10 Duncton Road,
Rustington,
Littlehampton,
W. Sussex,
BN16 3LA.
10/07/18.

I am writing to you with concerns over a notice for planning permission, for an end of terrace two storey dwelling to be built as part of a terraced property adjoining onto 8 Duncton Road.

Ref: R/134/18/PL

Drawing P03 May 2018 Scale 1:500 & 1:1250 @ A3
Planning Drawing - Block Plan & Location Plan

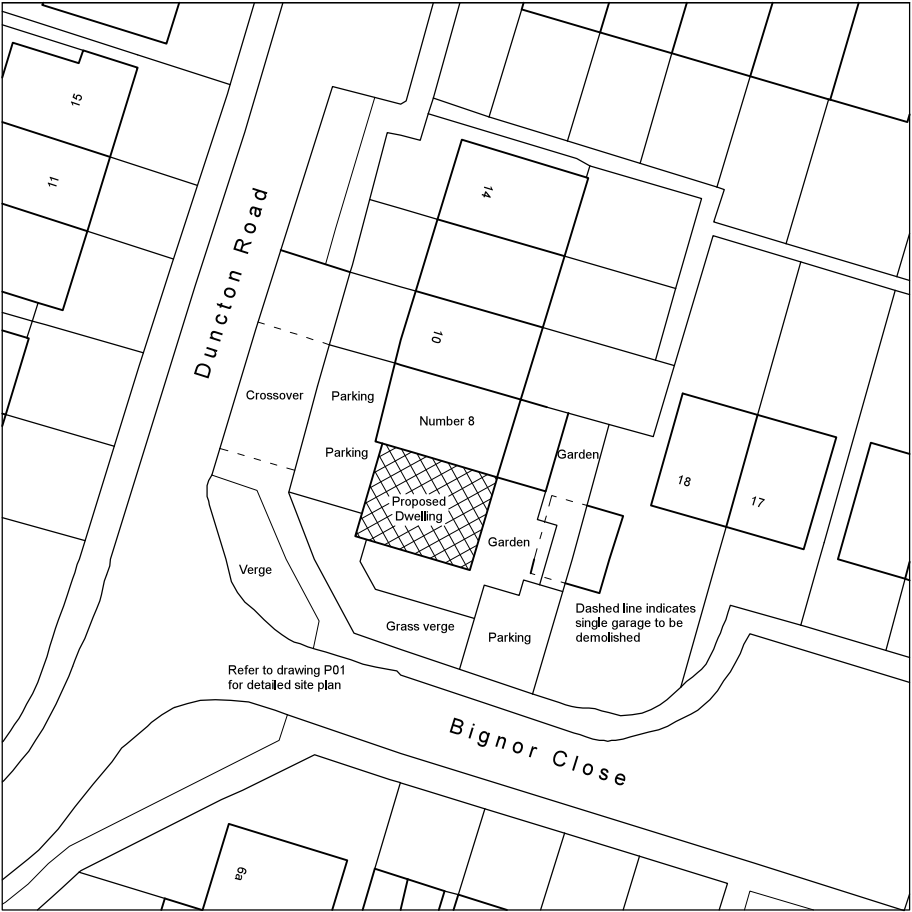
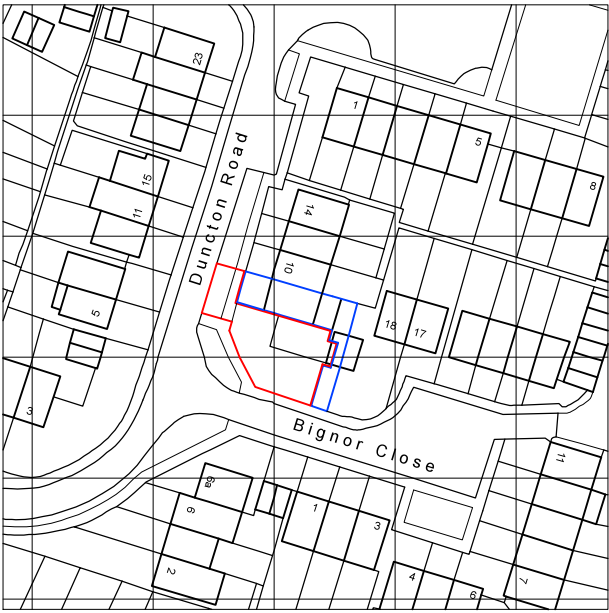
The new dwelling is proposed to be built past the building line of 18 Bignor Close, this does not match up with the house opposite - 6A Duncton Road as it has been suggested in this application. 6A Duncton Road has been built in line with the building line of 1 Bignor Close. They also did not tamper or remove the double garage - Please come to inspect.

Drawing P01      May 2018      Scale 1:100 @ A3  
Planning Drawing - Site Plan & Floor Plans

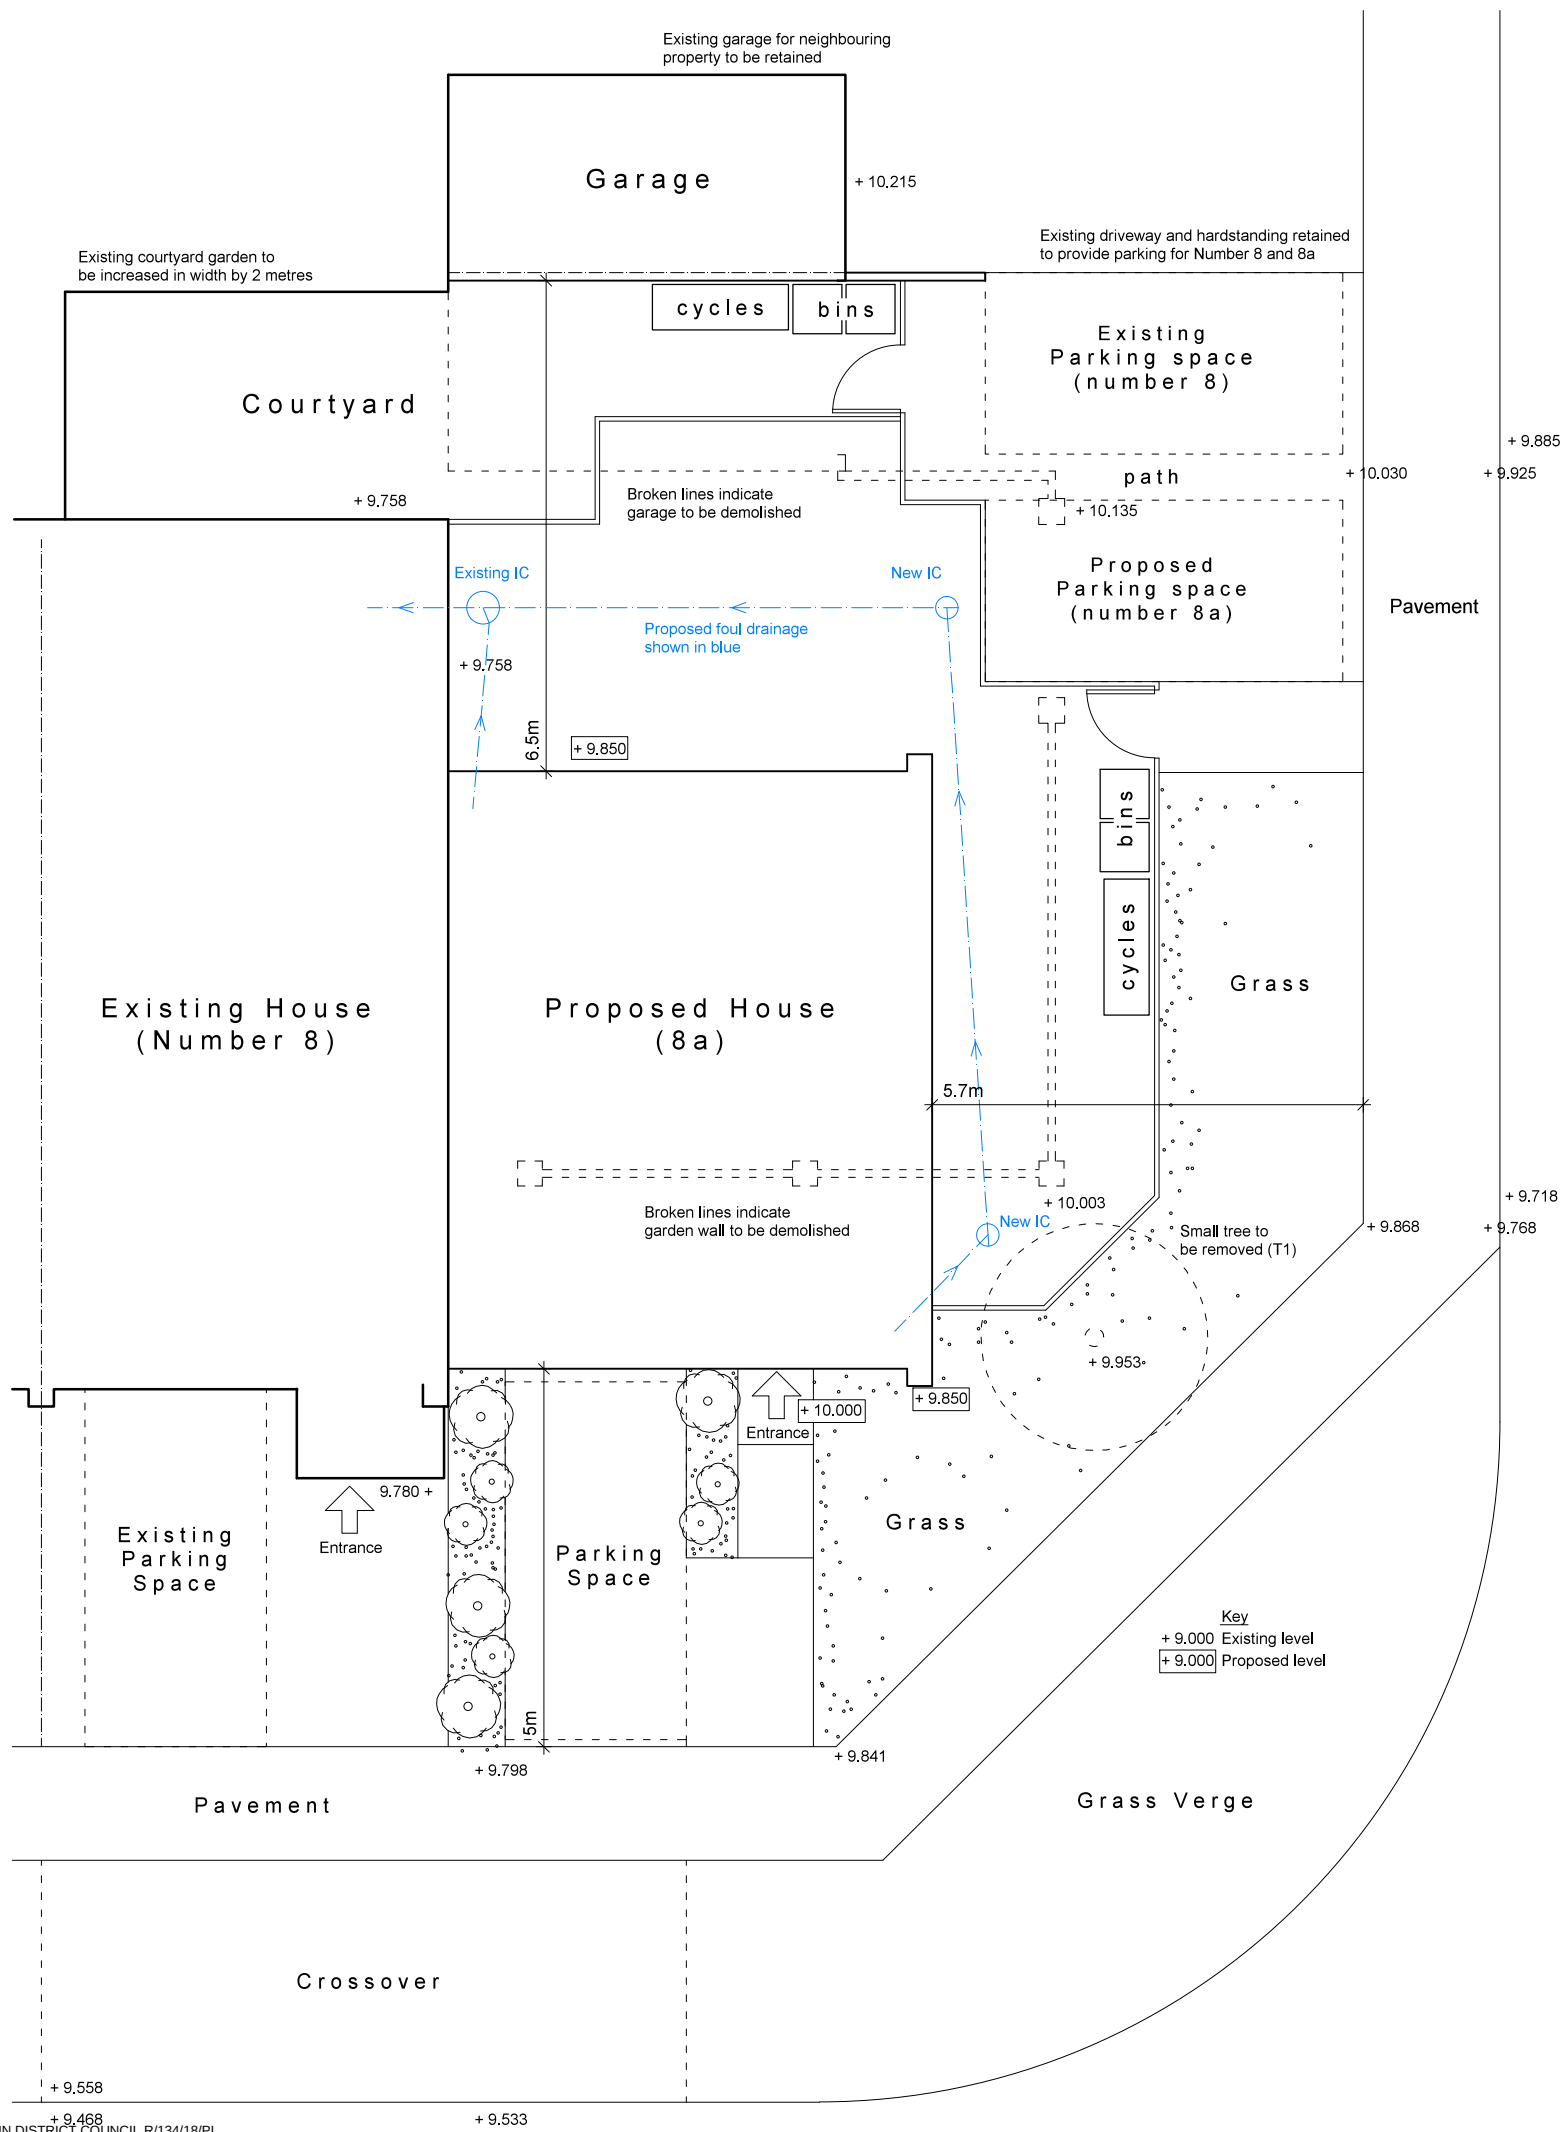
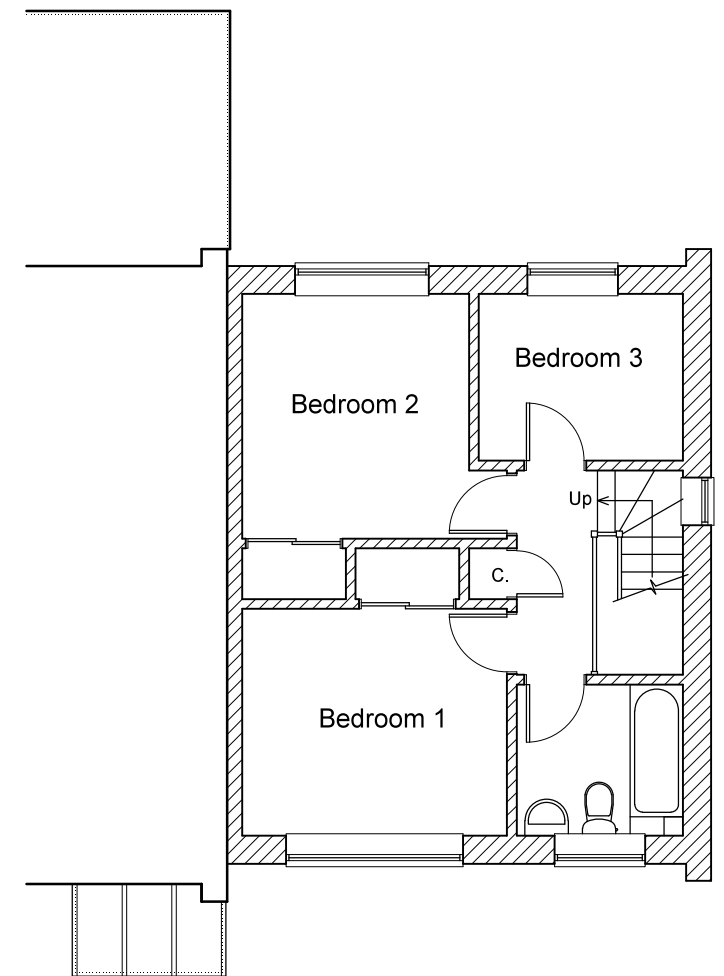
At the time No 8 added his rear extension they altered the sewage drainage pipes, with the new dwelling the plans indicate a further two inspection chambers added to the line. Can you confirm the foul run has the capacity to cope and the correct gradient of fall?

The plans also claim 8 Duncton Road has a current parking space at the front of his property. I can confirm he

does not. He has a front garden, but no driveway and no drop curb to access a driveway.
